# CITY OF ALBUQUERQUE

August 5, 2019

RE: **Mountain Townhomes**  
**1406 Mountain Rd NW**  
**Grading Plan Stamp Date: 7/26/19**  
**Drainage Report Stamp Date: 2/26/19**  
**Drainage File: J13D209**

Based on the submittal received on 7/29/19, the grading plan and drainage report are approved for Grading, Building, and SO-19 Permit.

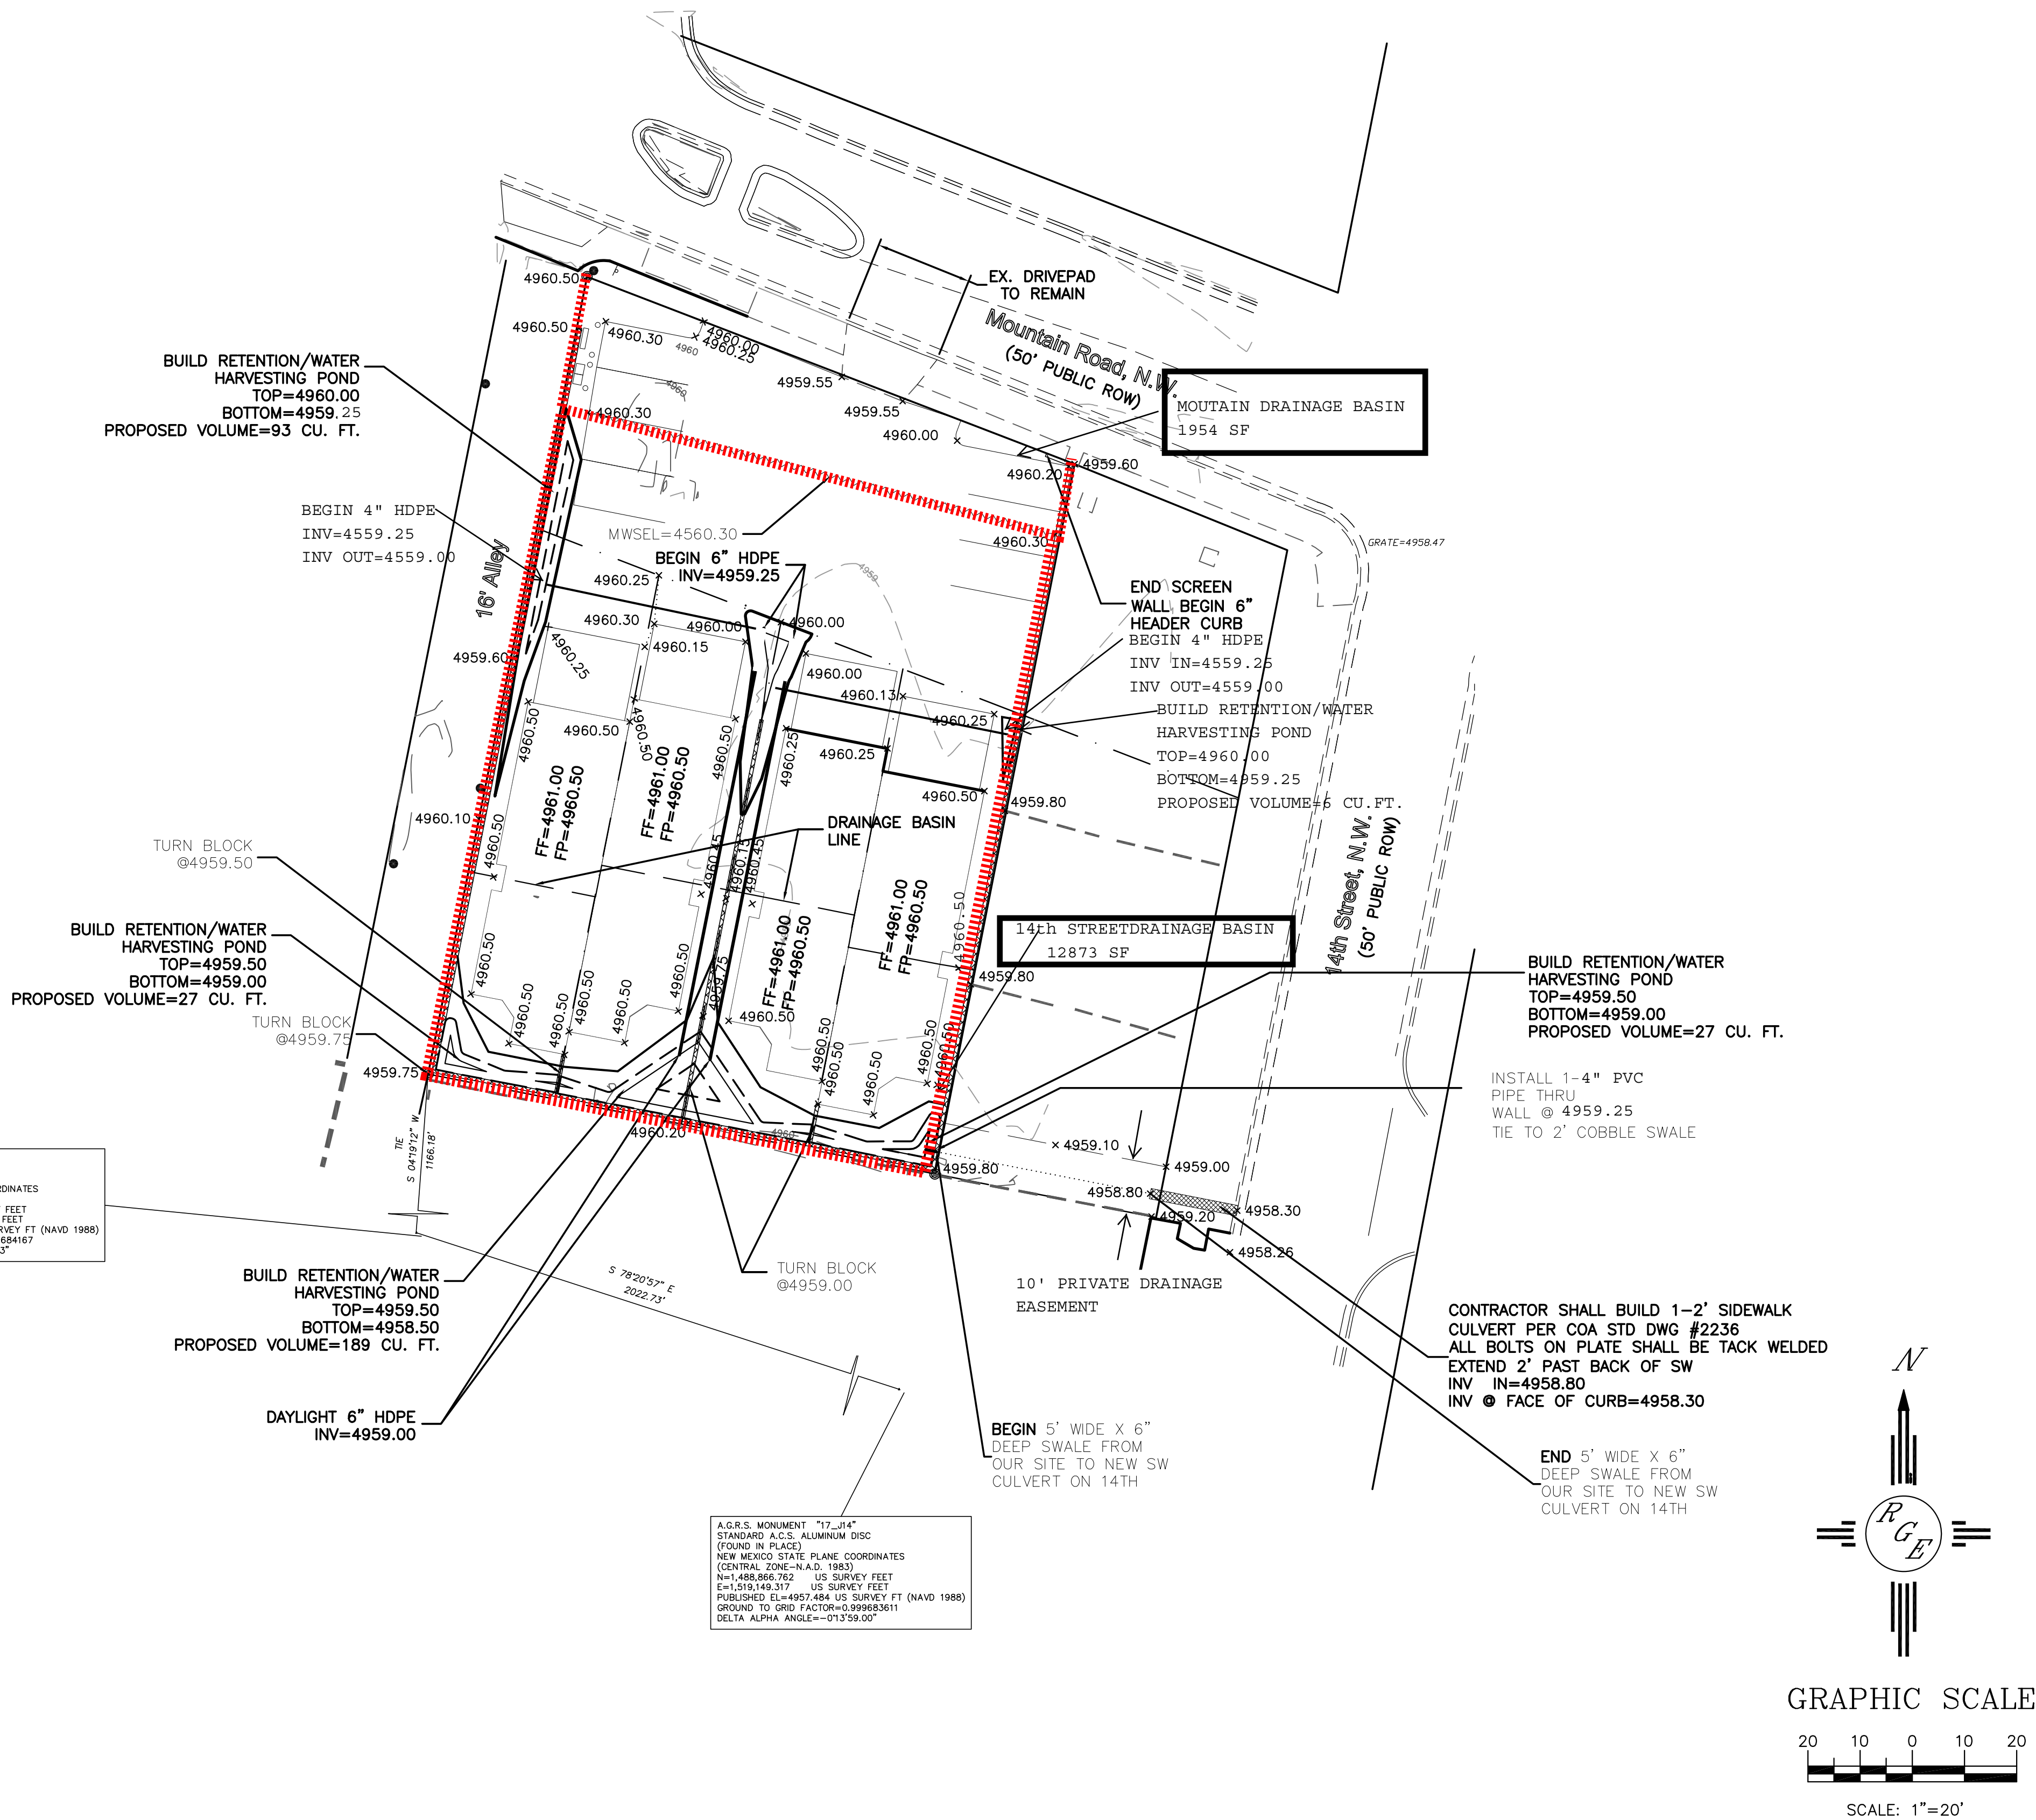
1. If an Infrastructure List is required by the DRB, then include the sidewalk culvert on it. Otherwise it can be built by SO-19. Please include the [standard SO-19](#) notes on the grading plan if true. **No infrastructure required. SO-19 notes added**
